Western Harbour Tunnel and Warringah Freeway Upgrade EIS

Peer Review of the Traffic and Transport Assessment

For Department of Planning, Industry and Environment

18 September 2020

FIGURE 4.9C - BERRY STREET NORTH (WHT8) CONSTRUCTION SUPPORT SITE LAYOUT

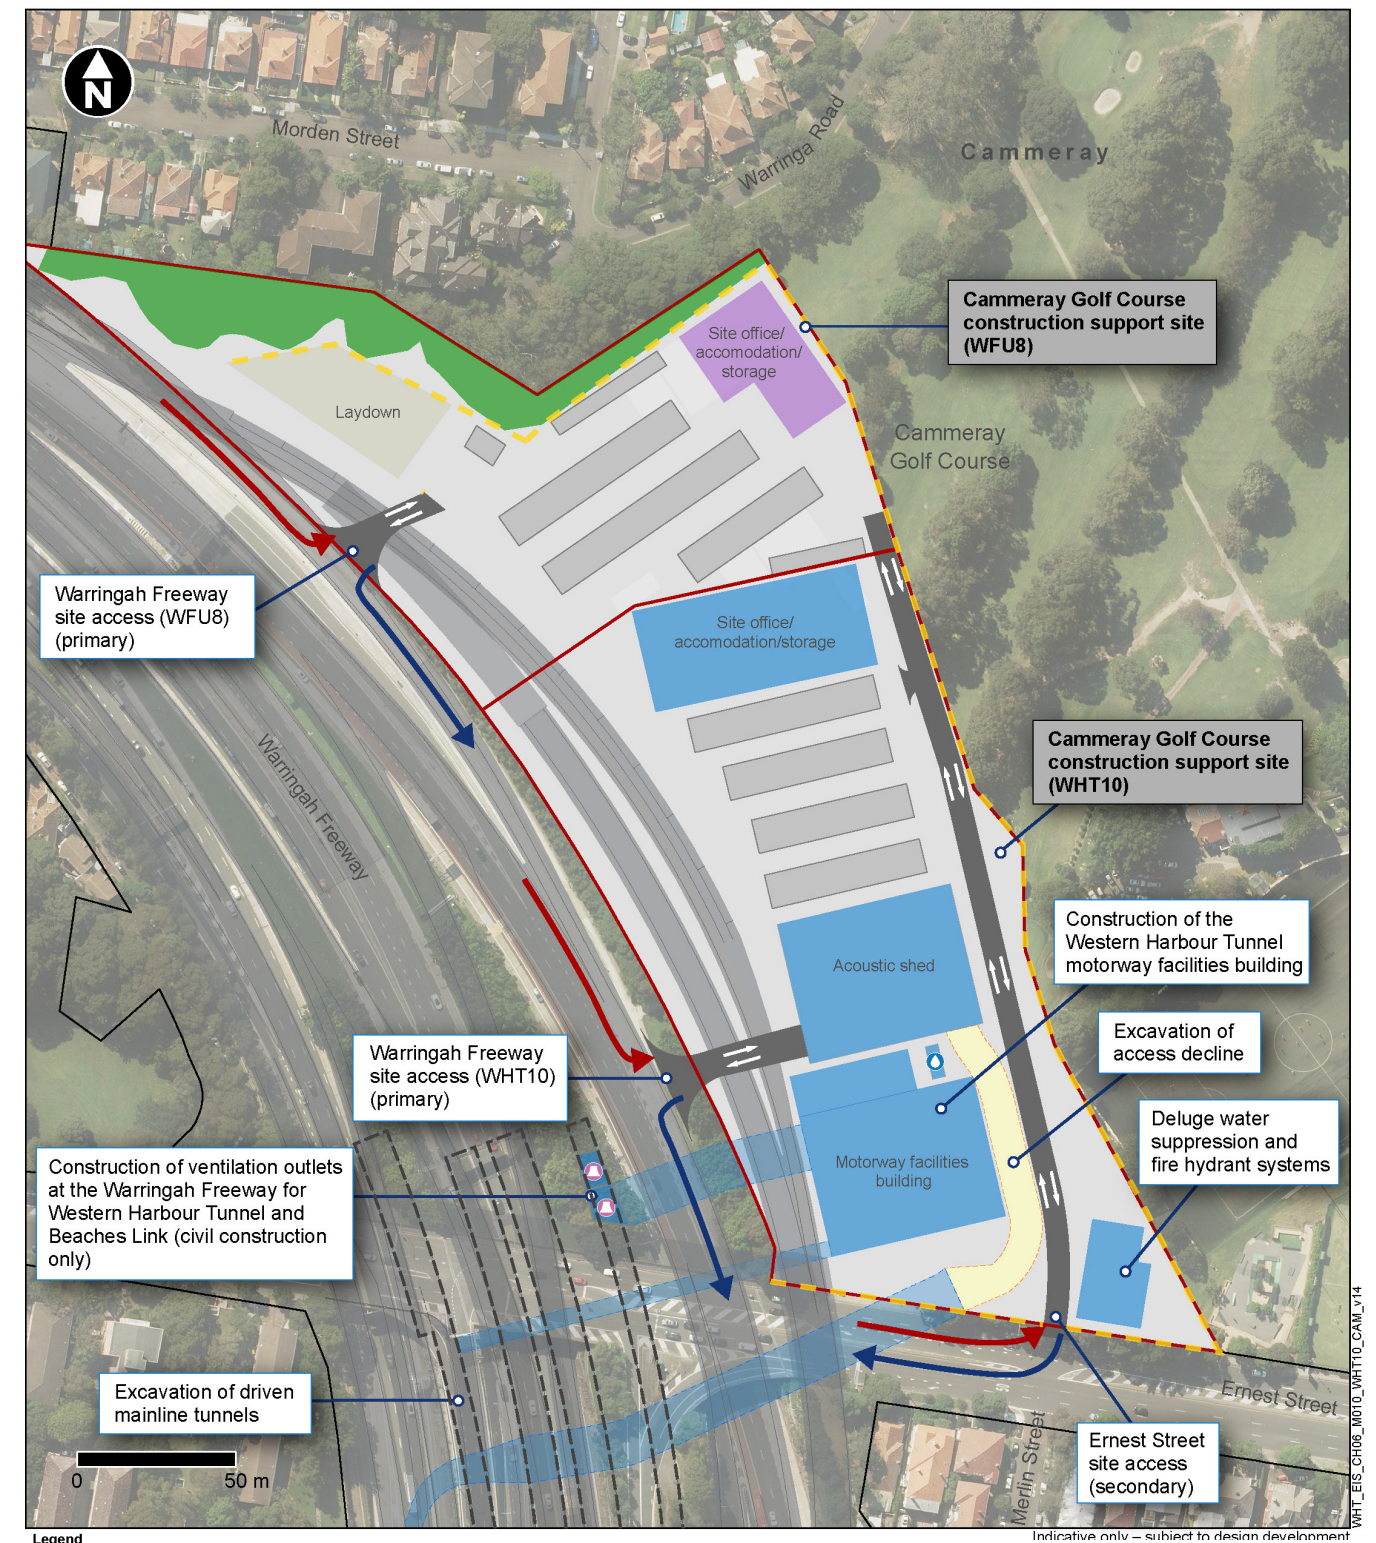
- Access to the Berry Street North site appears unlikely to be able to be safely achieved without full traffic control with associated traffic impacts and this has not been raised as an issue in the EIS. TfNSW's response to this issue is that it will be addressed with the CTMP however there is sufficient doubt now as to whether it can be addressed at all. Access to/from the two Cammeray Golf Course sites do not contemplate or dismiss the potential for a shared access point or the potential for truck acceleration lanes to minimise conflicts with Warringah Freeway traffic
